THE PADDINGTON SOCIETY Inc.
For Community and Heritage
Est 1964

Karen Harragon,
Director, Social and Other Infrastructure Assessments
Dept of Planning and Environment
20 August 2020

**Re: Sydney Football Stadium Stage 2 Modification 2 – Stadium Members Facilities
40-44 Driver Avenue Moore Park SSD-9835-Mod 2**

Figure 1 Comparison of exhibited (top) and proposed (bottom) detailing as viewed from Driver Avenue

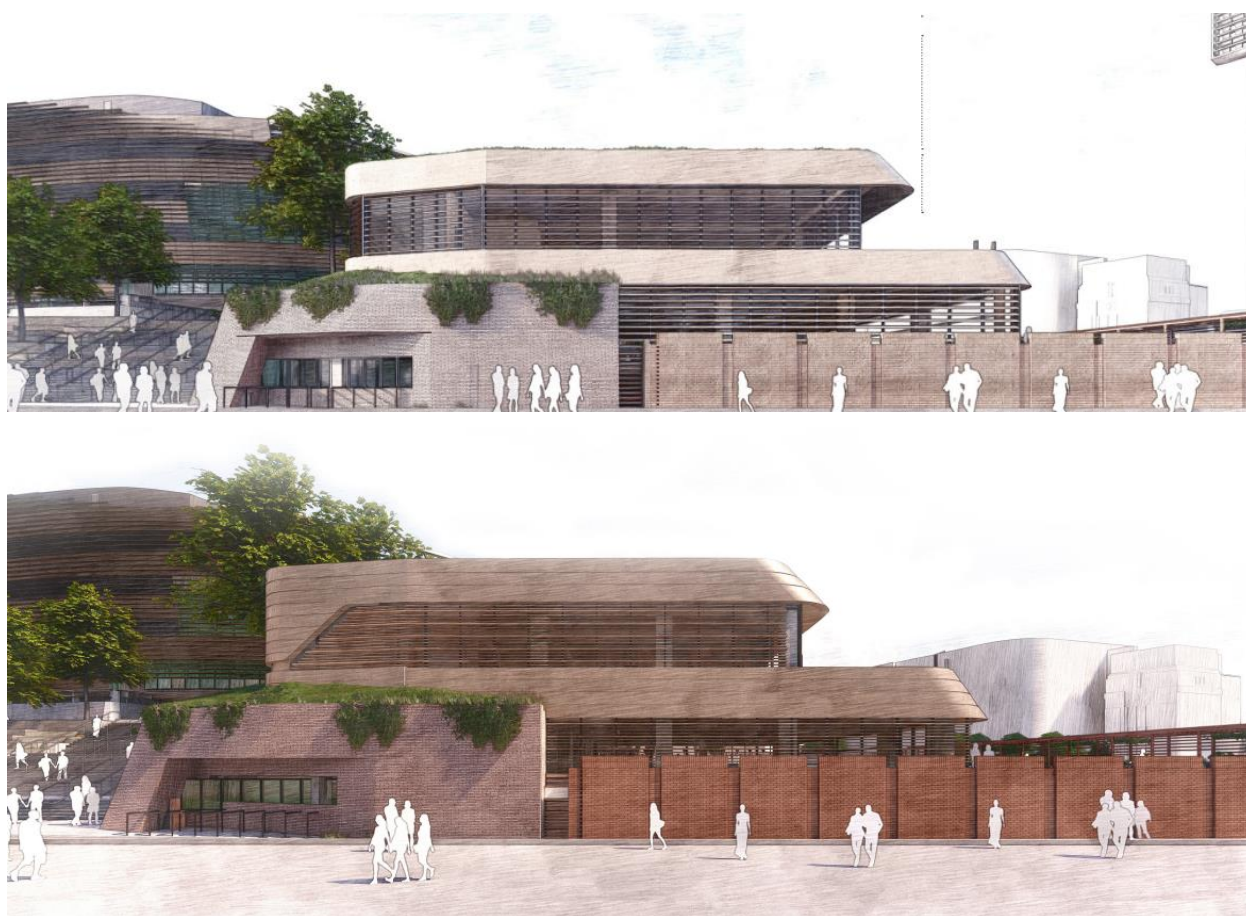
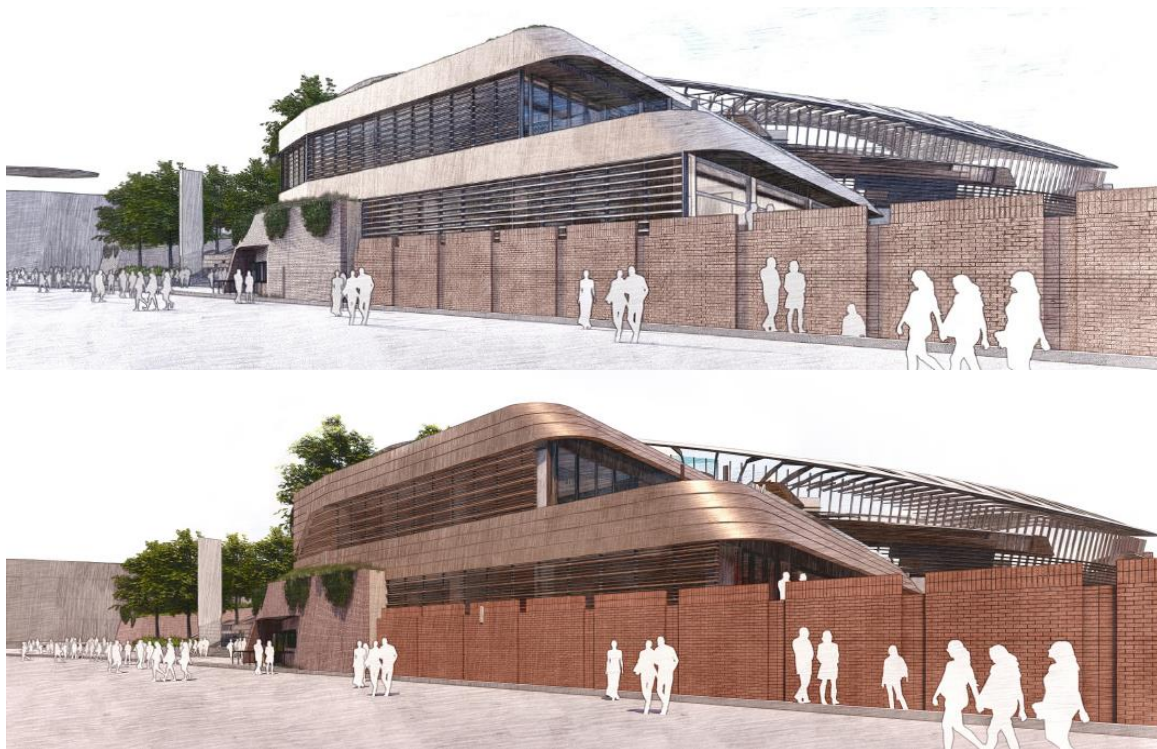
The proposal looks too high, top heavy and cluttered from many viewpoints, with a substantial 'pergola' structure on the top floor and heavy fascia elements at all levels, and brings more building bulk forward to viewers from Moore Park, and even detracts from the appreciation of the geometric Stadium shape. The proposal does not fulfil the stated design concept of the building as being a 'modest pavilion' 'predominately 1 storey in height' 'largely screened from Driver Avenue by the existing brick wall' (refer to Planning Statement and Architectural Design Statement).

The design would be improved, and be closer to the concept, by removing the top 'pergola' structure (there is a terrace below which can be used for functions), by setting the 2nd Concourse Level floor well back from Driver Avenue edge, to make it visually recessive, by lowering floor to floor heights

(currently 6m, 4.5m, 4.5m), and by planting out the entire roof for stormwater reduction and visual amenity when looking across from Moore Park and down from the main Stadium.

Figure 6 | Western Façade including main entry steps (Source: Applicant's Amended Modification Application, 2020)

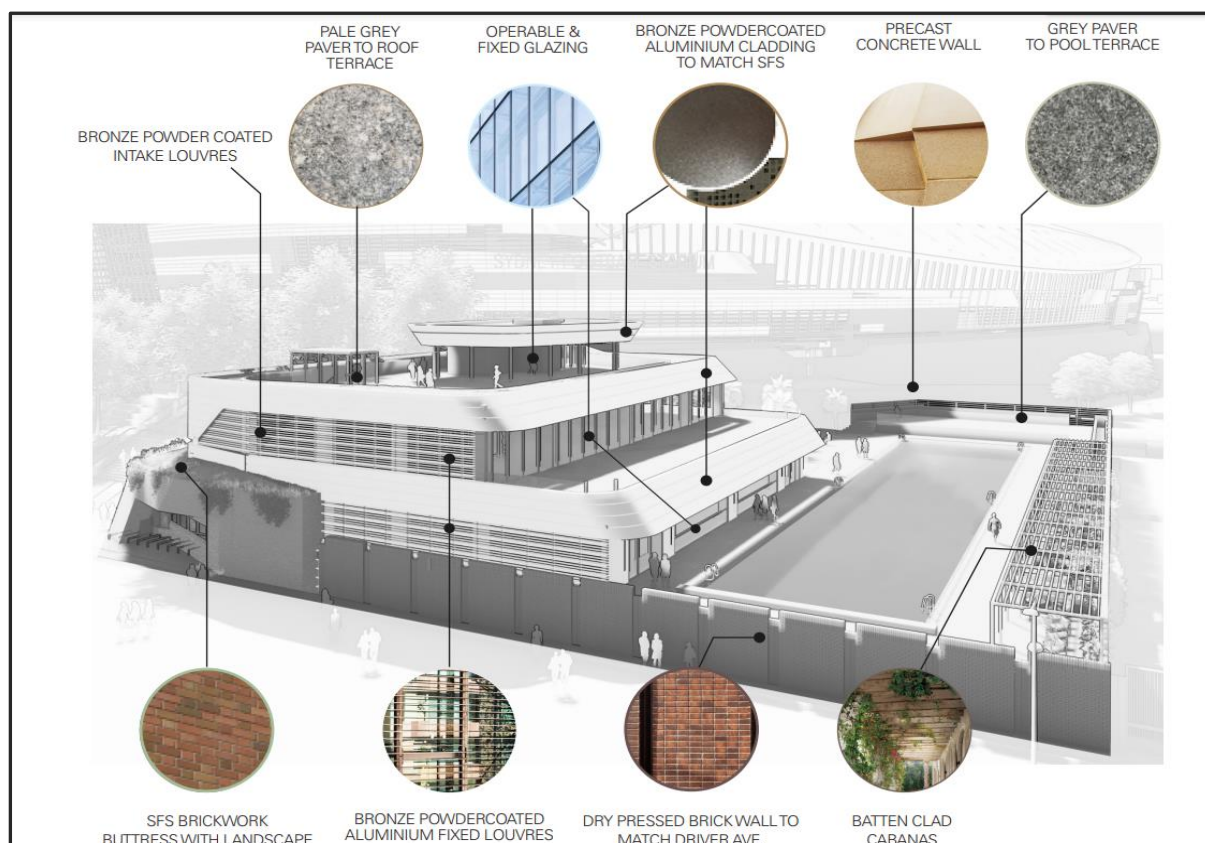
2. **The removal of part of the brick wall on Driver Avenue** is unfortunate from a heritage viewpoint , and it seems there were no alternatives explored. A successful reconstruction of the wall as a contemporary contrast will be very dependent on the details, and there should be a heritage oversight of this detail at a later stage.
